## Application for Removal or Variation of a Condition following Grant of Planning Permission or Listed Building Consent

Demolition of an existing 2-bed bungalow and erection of a new 4-bedroom bungalow with a habitable roof space, including side dormer, raising the ridge of the main roof, roof lights and solar panels.

57311/APP/2023/322

Condition 2

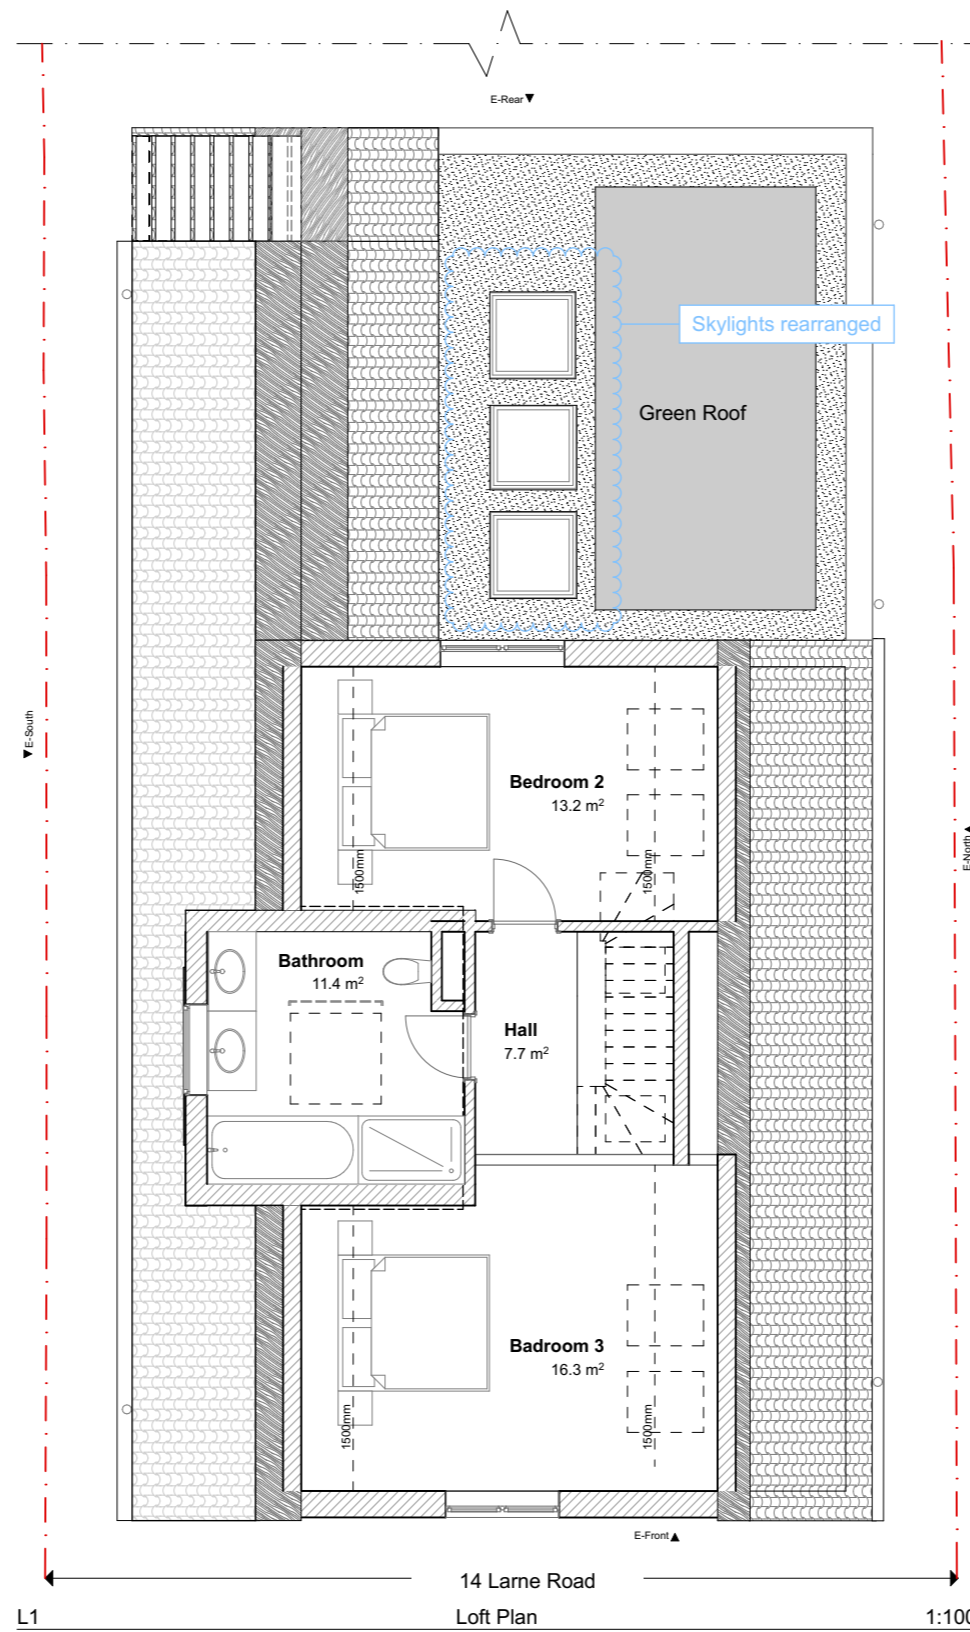
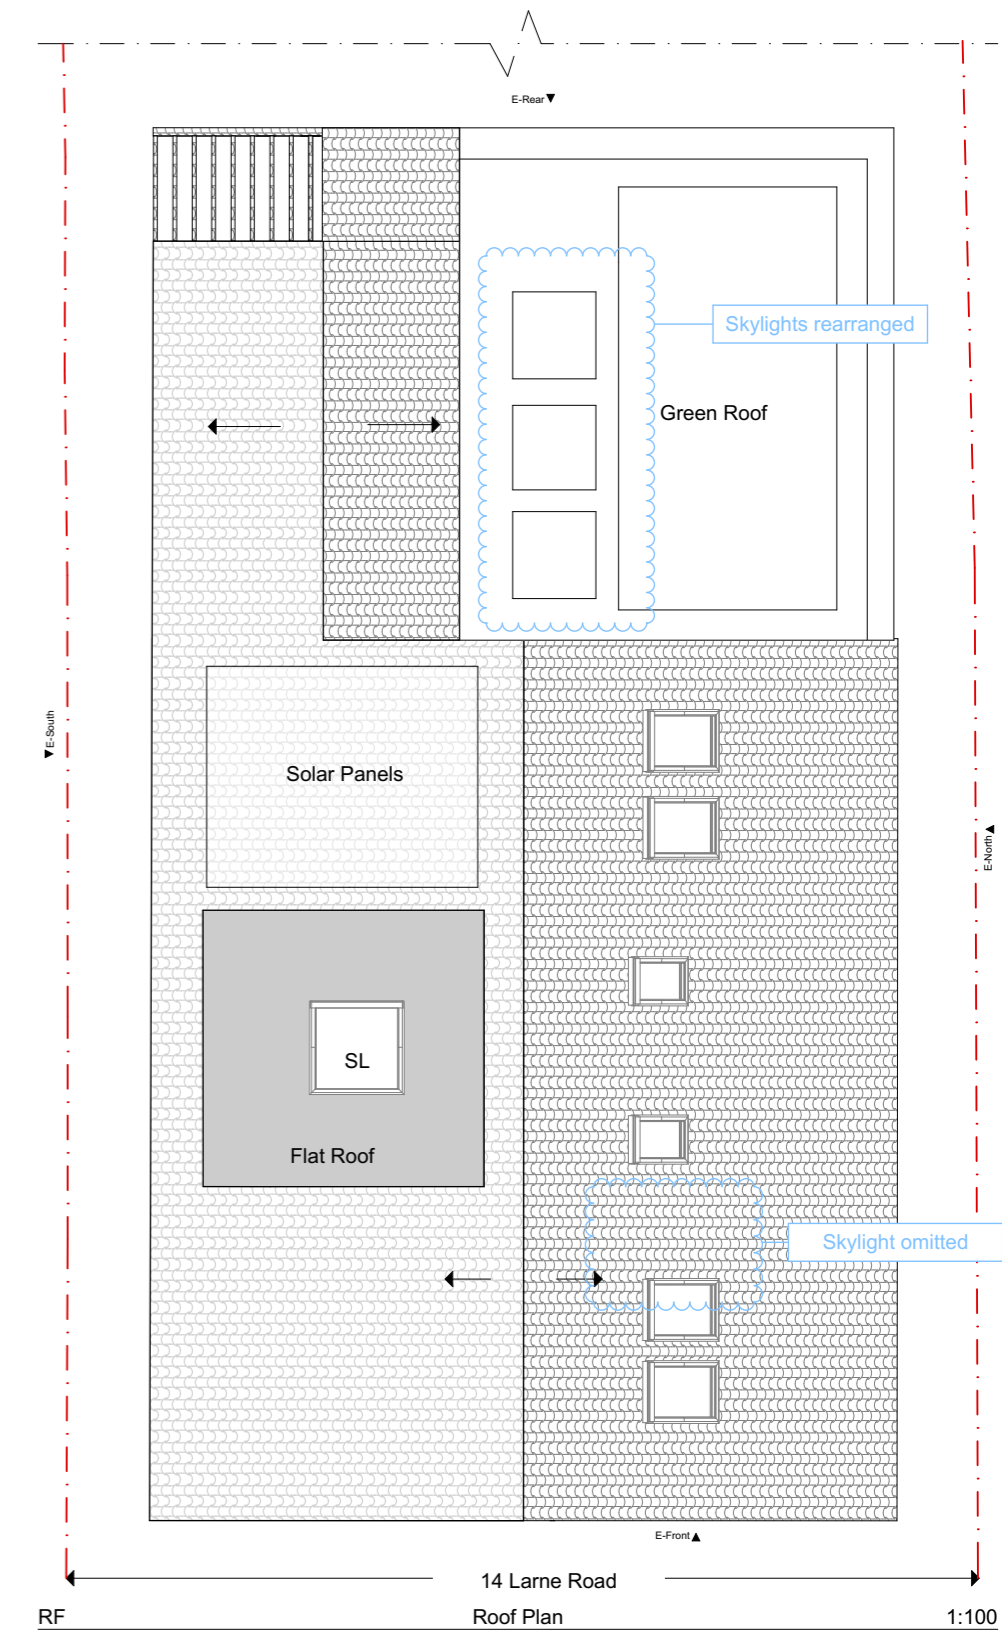
- 112 2207\_Existing & Proposed Street Elevation rev4 - Front elevation windows rearranged
- 210 2207\_Proposed Plans rev4 - Front elevation windows rearranged. North elevation - skylight omitted. South elevation - window added. Flat rear roof - skylights rearranged.
- 211 2207\_Proposed Elevation 1\_2 rev4 - Front elevation windows rearranged
- 212 2207\_Proposed Elevation 2\_2 rev4 - North elevation - skylight omitted. South elevation - window added

- 112 2207\_Existing & Proposed Street Elevation (rev 5)
- 210 2207\_Proposed Plans (rev 5)
- 211 2207\_Proposed Elevation 1\_2 (rev 5)
- 212 2207\_Proposed Elevation 2\_2 (rev 5)
